**ADC Planning Consultation
Conservation/Design Officer Response**

Application Number	Y/44/17/OUT
Address	Land at Stakers Farm, North End Road, Yapton
Description	New residential development within the setting of designated heritage assets
Case Officer	Simon Davis
Date	27 July 2017

TITLE	Proposed Site Layout	
SCALE	1:1000 @ A3	DWG NO. 3

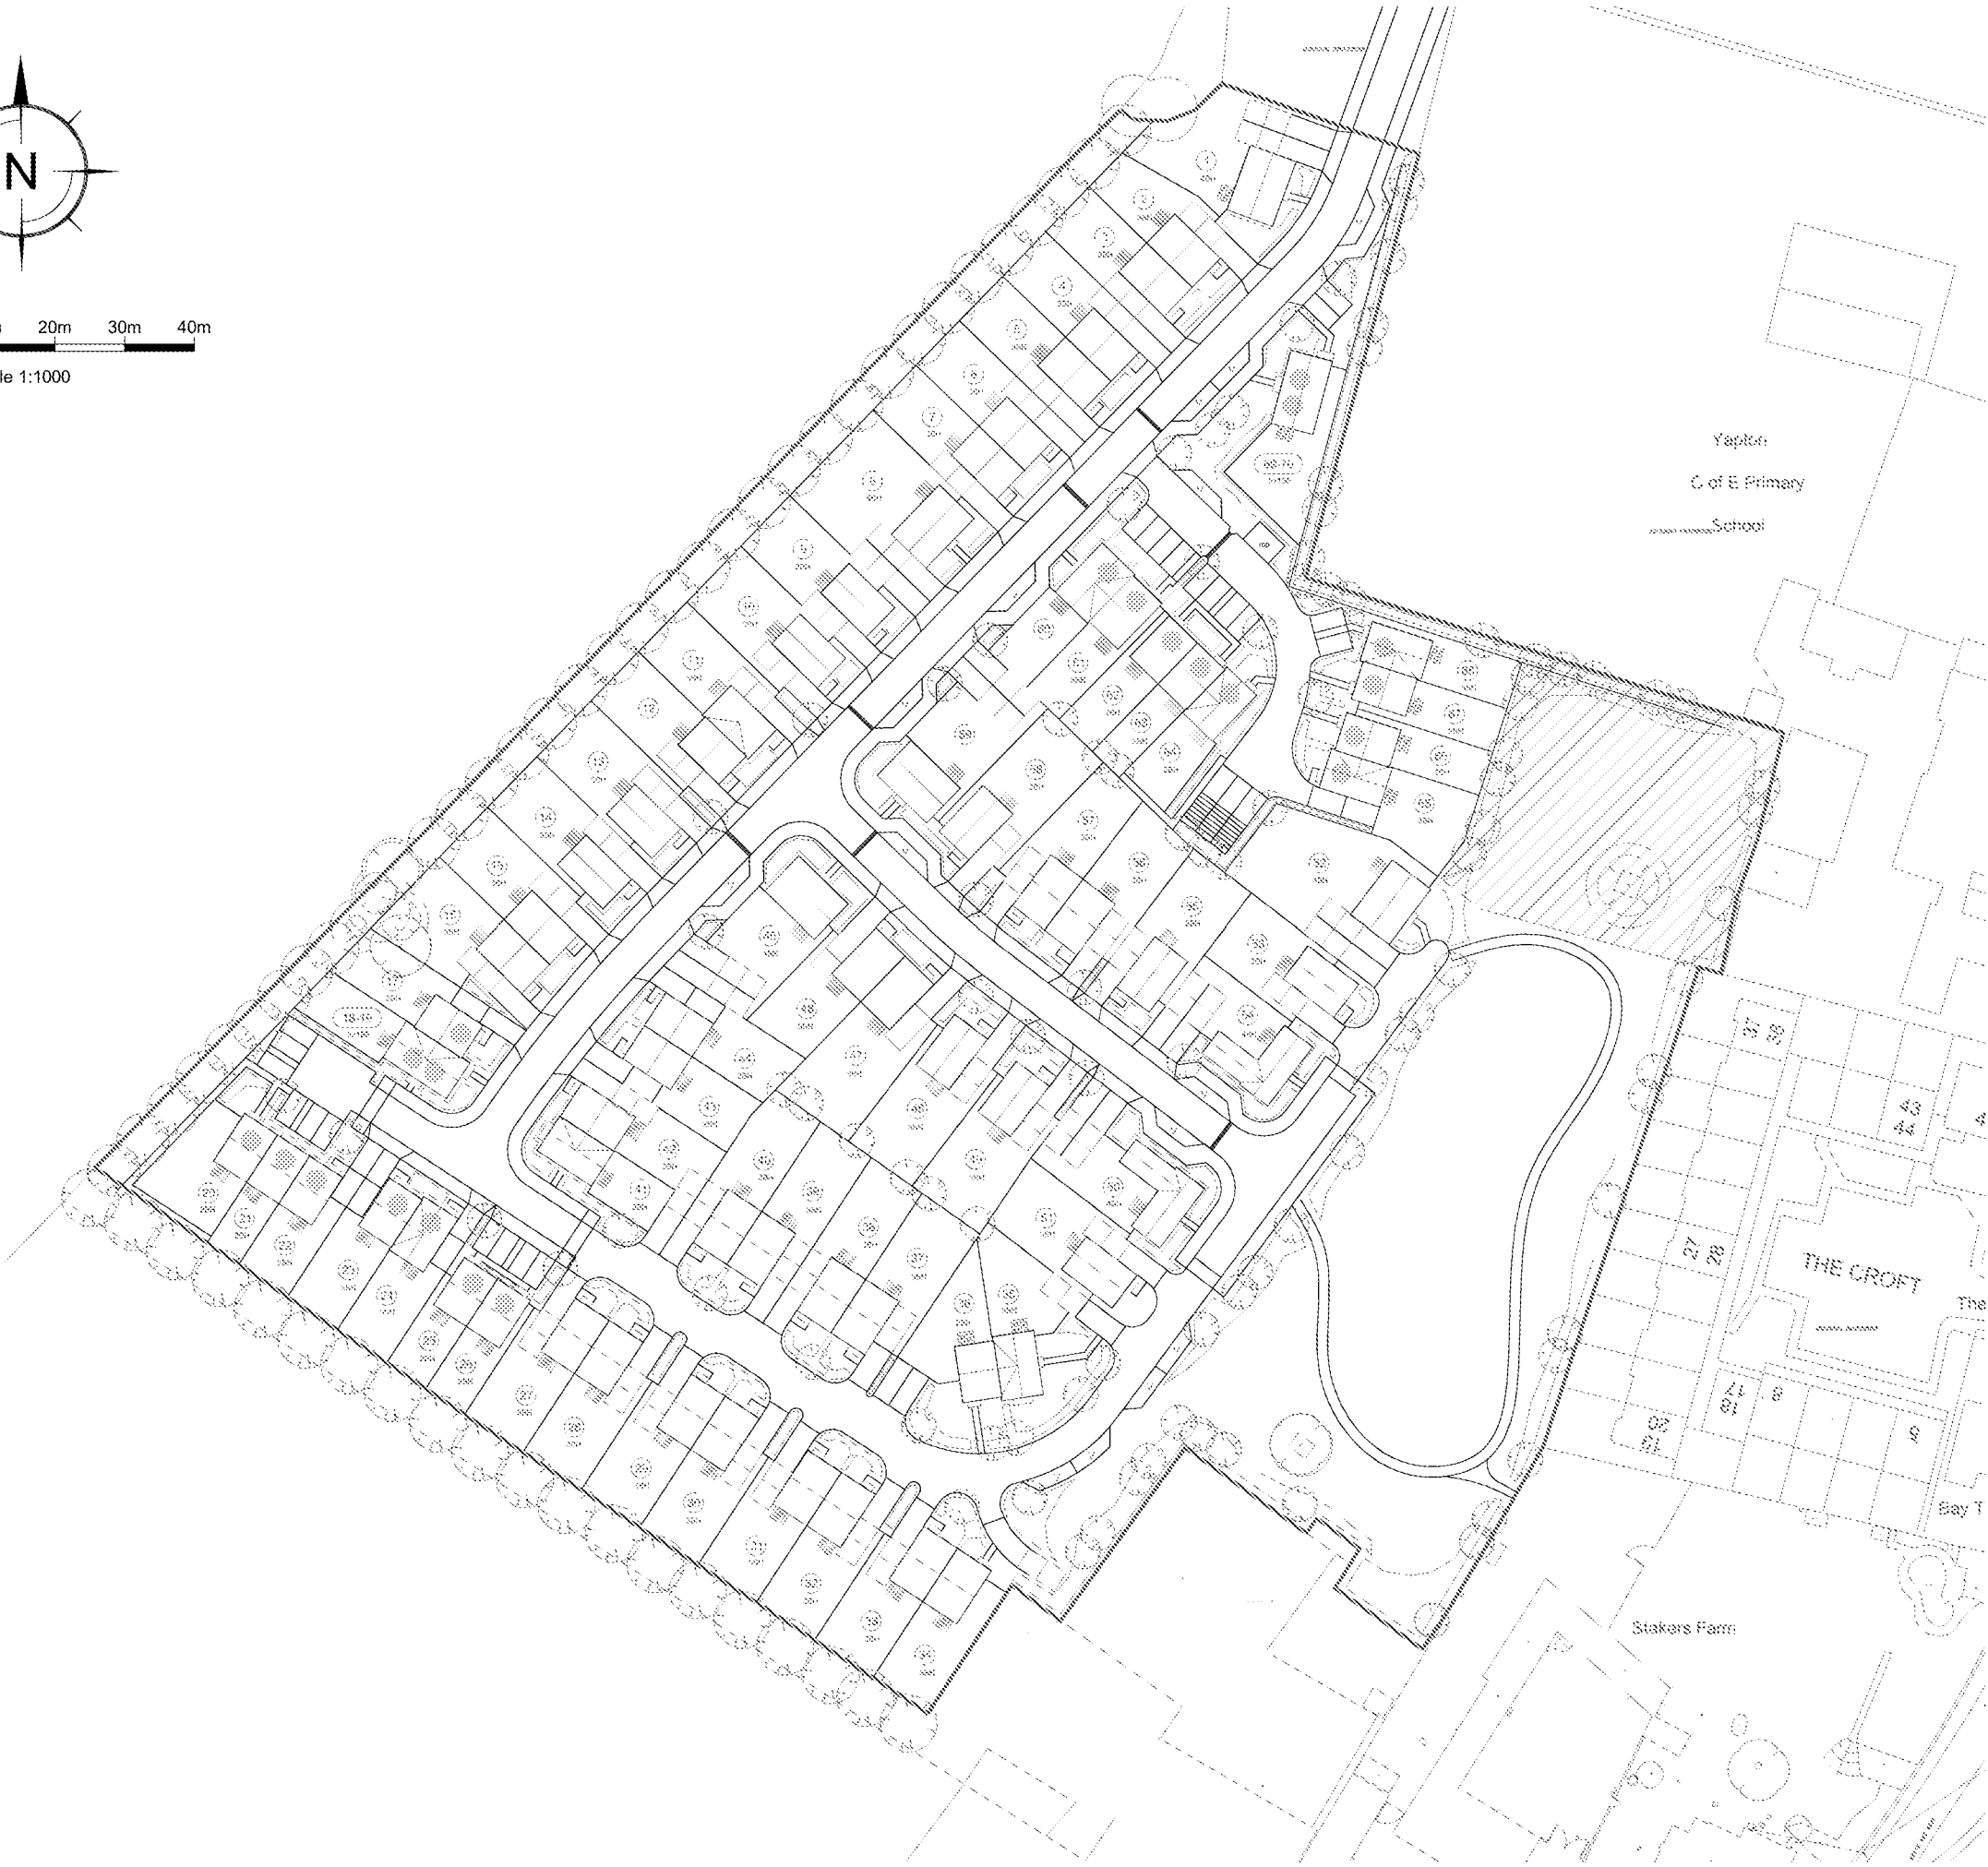
The rural context of the listed Farmhouse has been much compromised and only a narrow green 'buffer' to either side separates it from encroaching modern residential development to the north and to the south. The proposed development results in the loss of open farmland to the rear (west) which is essential to an understanding of the historic function of the building and its importance in the wider landscape.

Due to the relatively flat topography and the presence of intervening buildings, the new development is unlikely to be experienced in the background of views of the listed building from the public realm. However, it will feature strongly in views to the west from the listed building and entirely transform their quality from rural to suburban.

The proposal results in the listed Farmhouse being engulfed in a sea of residential development which obscures its intended function and diminishes its pre-eminence in the landscape. The distinction between what was historically a relatively isolated group of agricultural buildings and the nearby settlement of Yapton is entirely lost and the significance of the heritage asset is harmed in consequence.

Section 5.3 of the DAS notes that the scale of development will be reduced towards the development edges and that building heights 'will generally be two storeys...'. This is welcomed as compatible with local village models. However mention is made in other sections of small blocks of flats and more dominant landmark buildings, and it is questioned whether greater height in the built form is appropriate to the local context, where modestly scaled village buildings rarely exceed two storeys. Landmark buildings should be primarily defined by variety in detail and any increase in height kept to a minimum.

While the green buffer and well planted boundaries between the new development and the established buildings to the east are welcomed from the conservation perspective, it is nevertheless noted that both pedestrian and vehicular access is very constricted. This is likely to result in lack of connectivity between the new development and the existing settlement, and this aspect should be further reviewed elsewhere in the planning process.
